Appeal Decision

Appeal Ref: APP/R5510/W/21/3288965

31 Clevedon Gardens, Hayes UB3 1RD

- The appeal is made under section 78 of the Town and Country Planning Act 1990 against a refusal to grant planning permission.
 - The appeal is made by Mr Jaswant Thind against the decision of the Council of the London Borough of Hillingdon.
 - The application Ref 75243/APP/2021/1759, dated 23 April 2021, was refused by notice dated 16 September 2021.
 - The development proposed is for new 2 bedroom chalet bungalow with parking and amenity space and demolishing the existing garage of the principal dwelling at No 31 Clevedon Gardens Drive.
-

Project	LAND ADJACENT TO 31 CLEVEDON GARDENS HAYES MIDDLESEX LONDON, UB3 1RD		
Title	PROPOSED SITE PLAN SWEPT PATH DIAGRAM		
Scale	Drawn	Approved	Date
1:150@A3	JTS/FA		FEB 21
Job No.	Drawing No.		Rev.
DE-775	P-31 CG -06

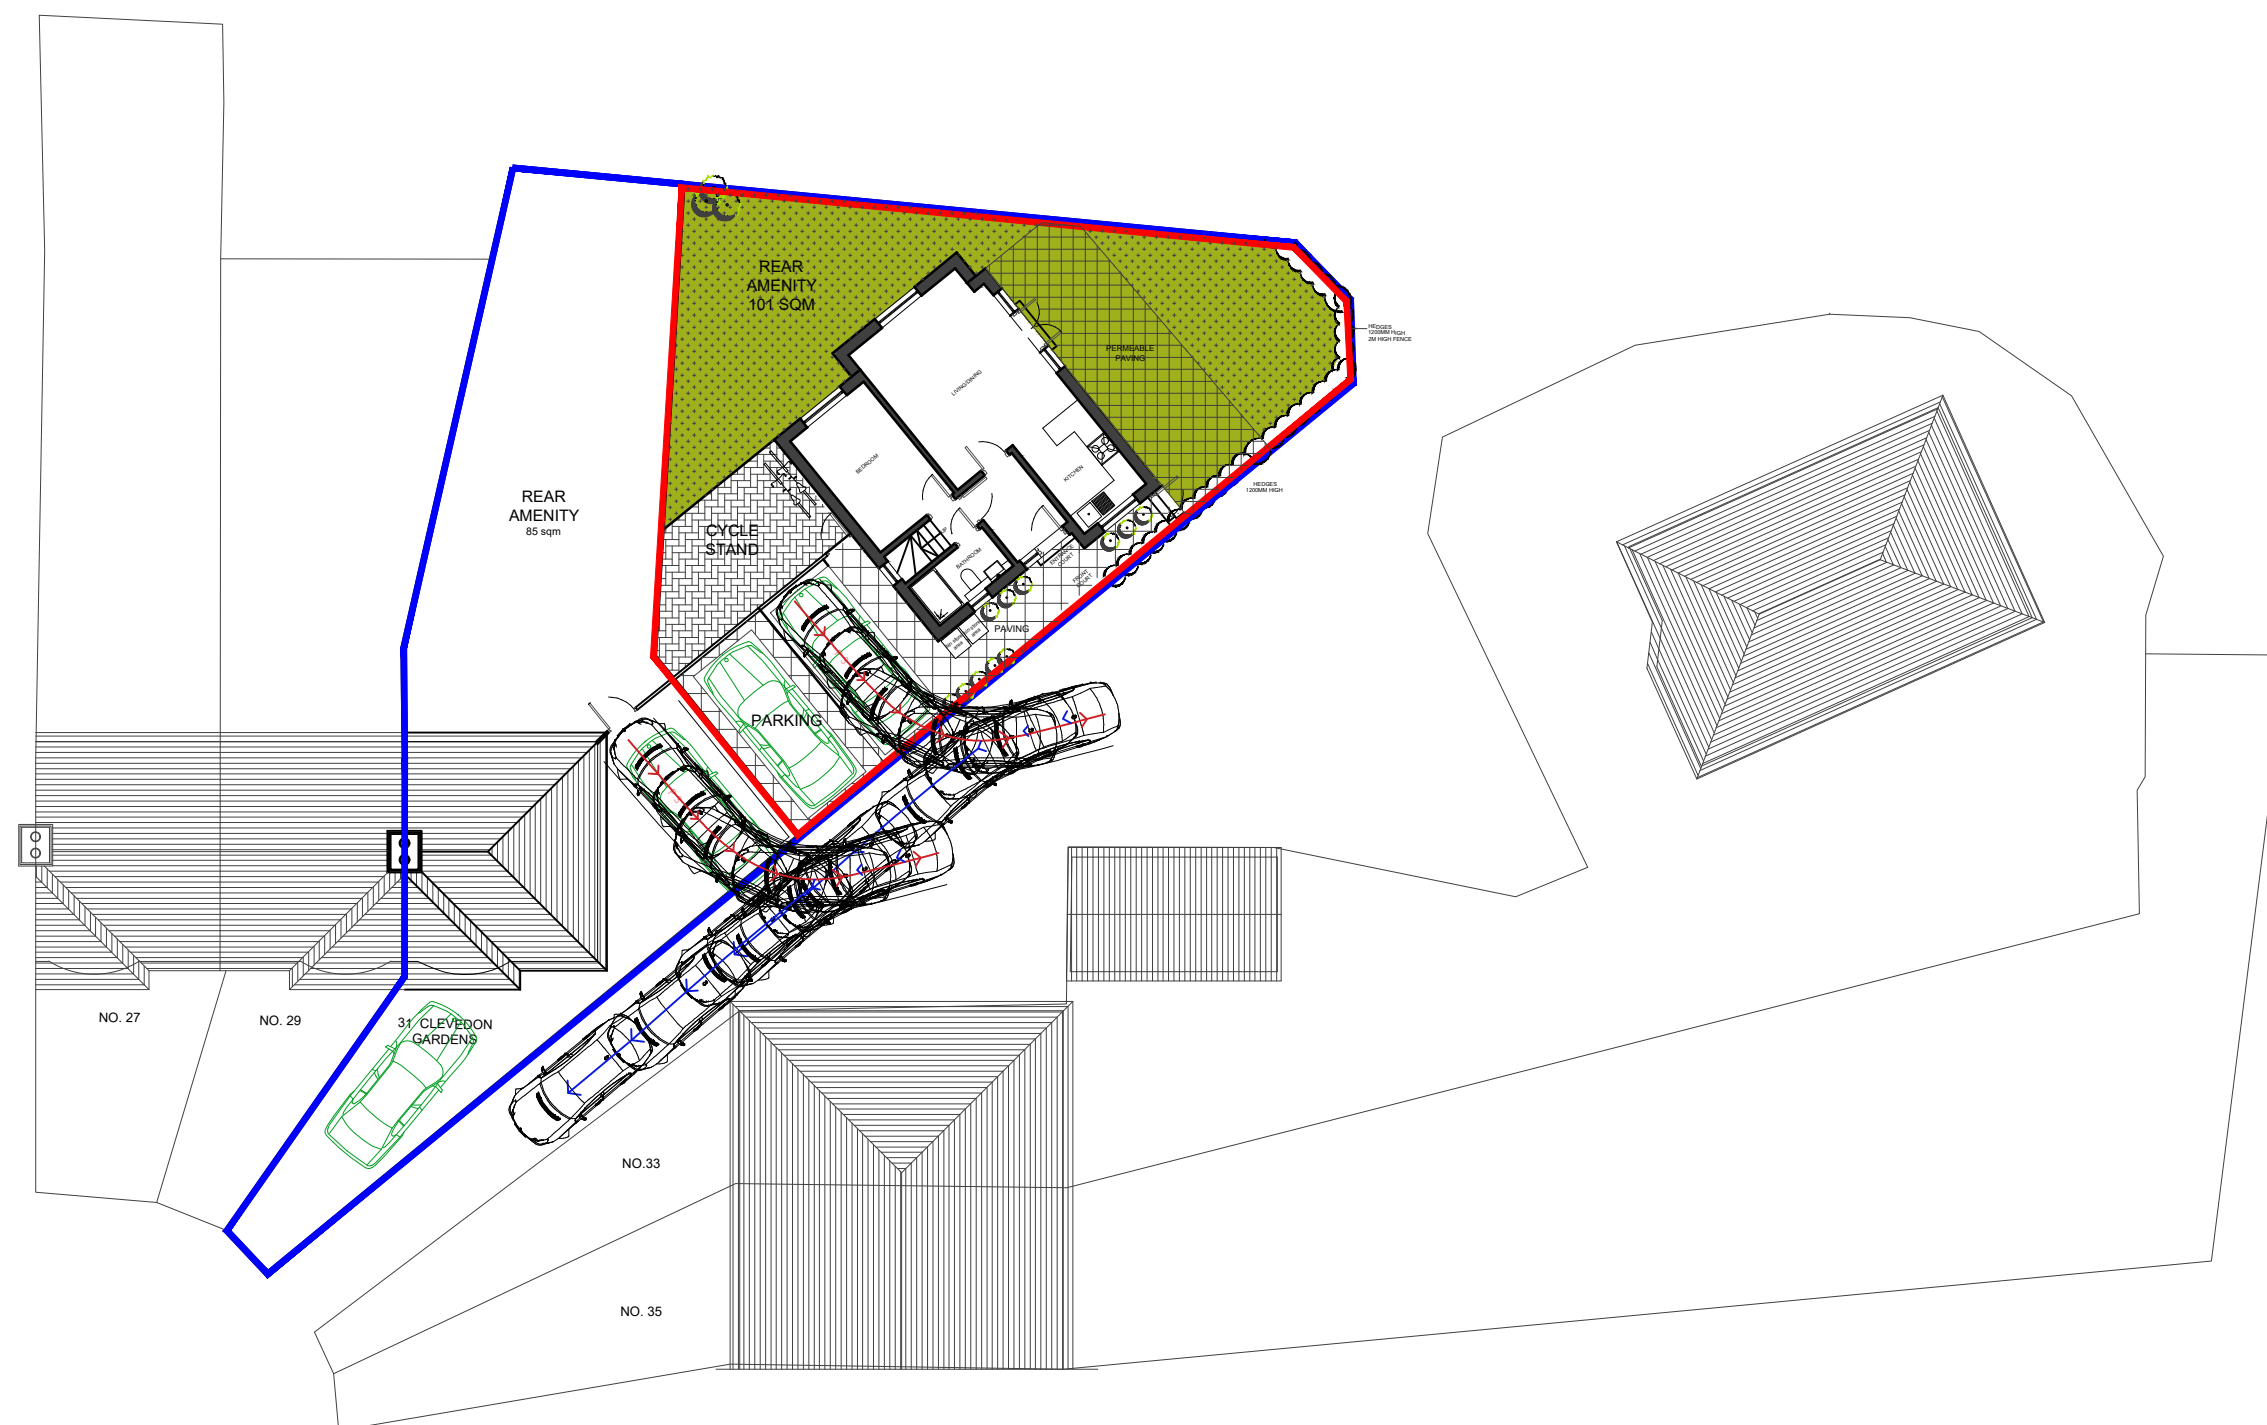
16. However, the second of the spaces would be located adjacent to No 31's flank elevation. The appellant's swept path diagram¹ shows that a car, parked parallel to the boundary with the proposed dwelling, could reverse out and then exit the access track in a forward direction. However, what it does not demonstrate is how the vehicle would access that particular parking spot in a forward direction.

17. The width of the access is restricted by the front corners of Nos 31 and 33. It would be possible to drive in and pull in parallel to No 31's flank, but not in the manner shown on the swept path. Nor does it show how either of the parking spaces for the proposed dwelling would be accessed in a forward motion where the width of the access, and thus the manoeuvring space, is heavily constrained by existing buildings, potentially parked vehicles and by the limitations of the appeal site's extent.

18. Given the limited, and already heavily used, on-street parking and the restricted space around the tight turning head, the proposal's failure to demonstrate accessible parking provision or adequate and usable access and manoeuvring space would be prejudicial to highway and pedestrian safety. As

¹ Drwg No: P-31 CG -06 – 'Proposed Site Plan Swept Path Diagram'

such, the proposal fails to demonstrate safe and efficient vehicular access to the highway network or adequate provision for access to, and manoeuvring into and out of, the parking spaces provided within the proposal, contrary to LP2 policies DMT2 and DMT6.

Project LAND ADJACENT TO 31 CLEVEDON GARDENS
HAYES MIDDLESEX
LONDON, UB3 1RD
Title PROPOSED PLANS & ELEVATIONS

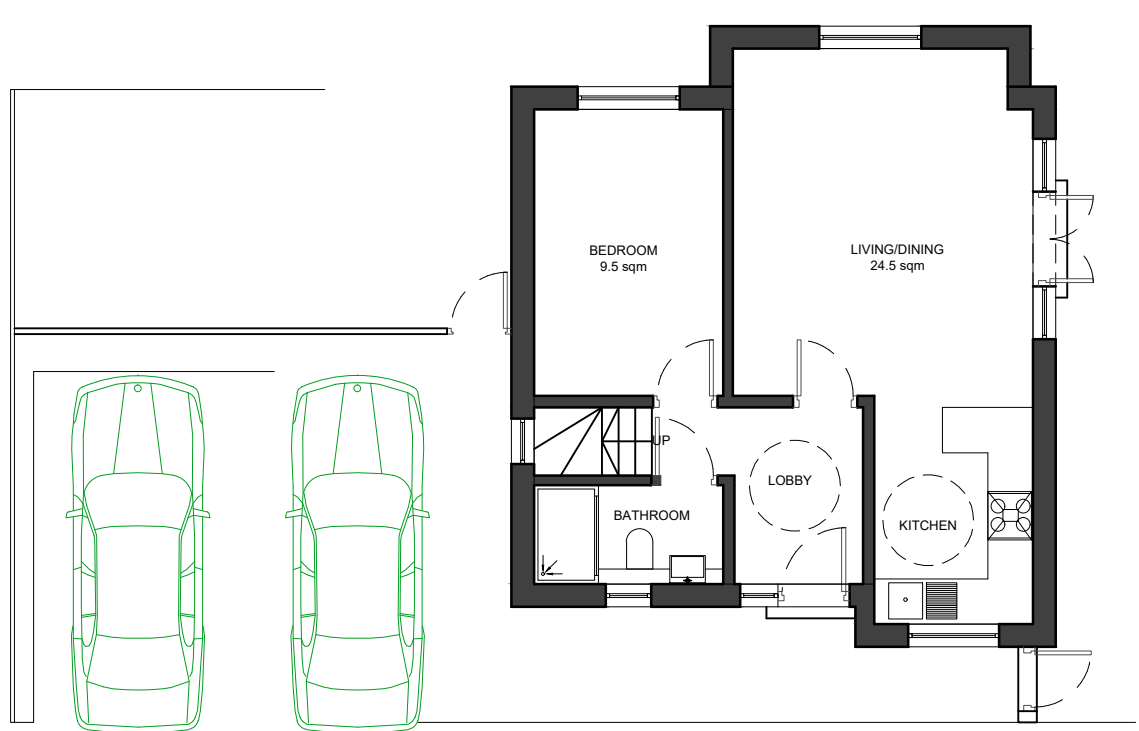
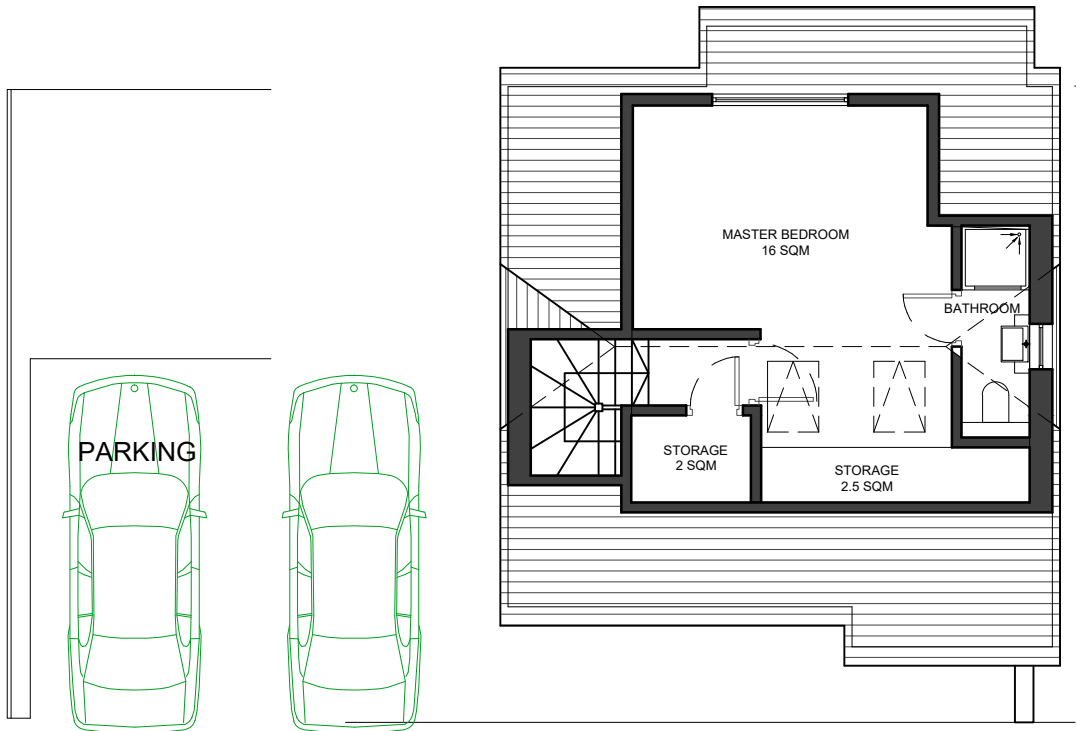
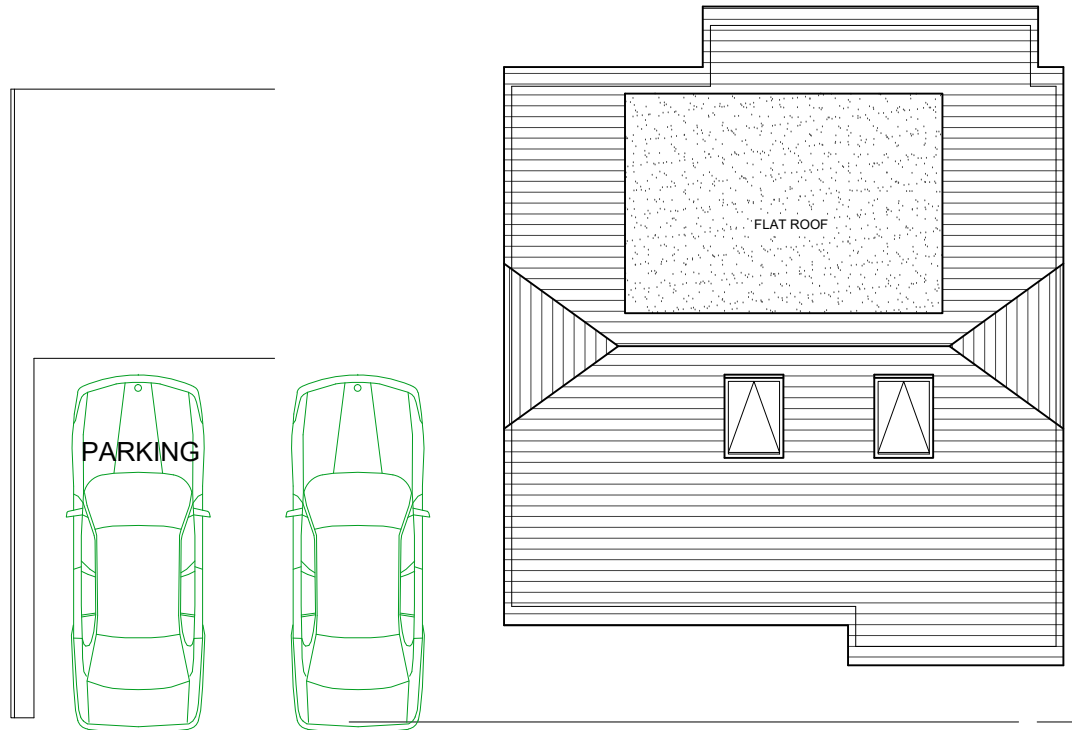
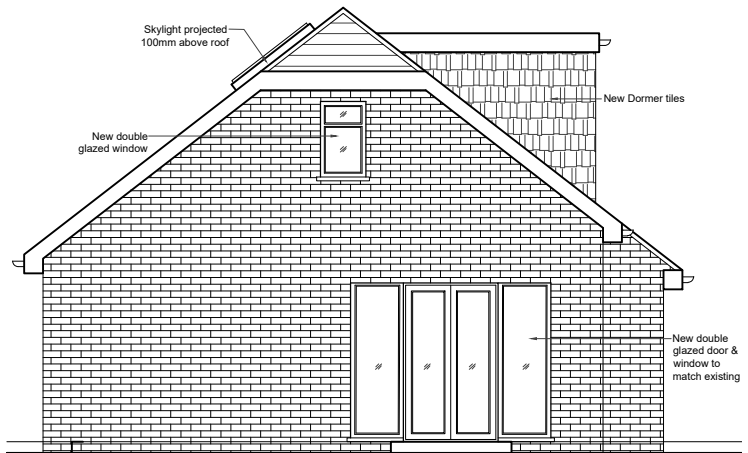
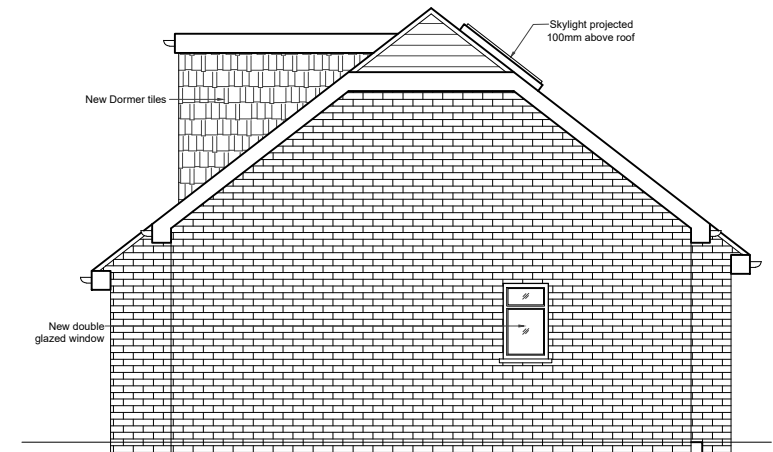
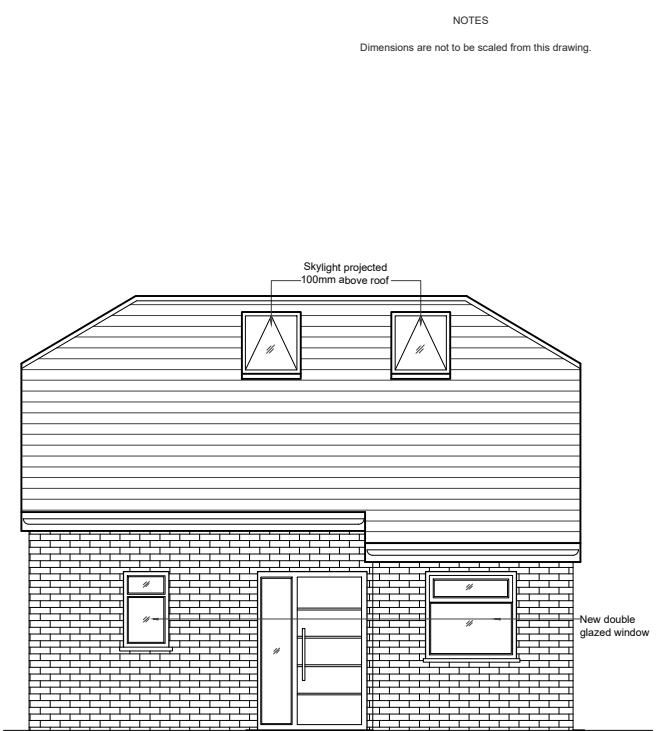
9. Whilst that may be so, there are other factors to consider in assessing the effect of a proposal on character and appearance. The proposed dwelling would be an altogether larger structure than the existing outbuilding, its size and bulk due principally to its disproportionately large roof structure and substantial rear box-dormer window. It would, as a consequence, have something of an awkwardly top-heavy appearance, setting it at odds with the generally consistent, prevailing style, form and character of the terraced blocks.

10. Moreover, the building would be positioned very close to the site's frontage on the narrow access track. Because of its orientation within the plot its rear corner would also be very close to the rear of the site. This would compound the incongruous nature of the proposal's location at the rear of the terraced block and its bulky appearance, resulting in a cramped and discordant form of development at odds with the area's prevailing pattern and form of development.

11. Whilst garden buildings are not entirely without precedent, they tend to be smaller structures than that proposed in this instance. The building's ridge height and overall scale may be less than those of the existing terraced buildings, but this would not make the proposal any less dominant within the context in which it would be located. Nor would the large and angular box dormer window or awkward half-hipped roof be consistent with the prevailing roof forms of Clevedon Gardens and neighbouring streets.

19. The third of the refusal reasons relates to the shortcomings of the proposed dwelling's internal layout, with particular regard to bathrooms. A revised internal layout has been submitted within the appellant's Appeal Statement which suggests how this reason for refusal could be overcome.

20. Although not previously before the Council, the Council acknowledge that these matters could be adequately dealt with by way of a planning condition as internal alterations. I see no particular reason to disagree. However, the use of a condition (or conditions) to secure this matter would clearly not address the matter of the harm I have identified in respect of the main issues.
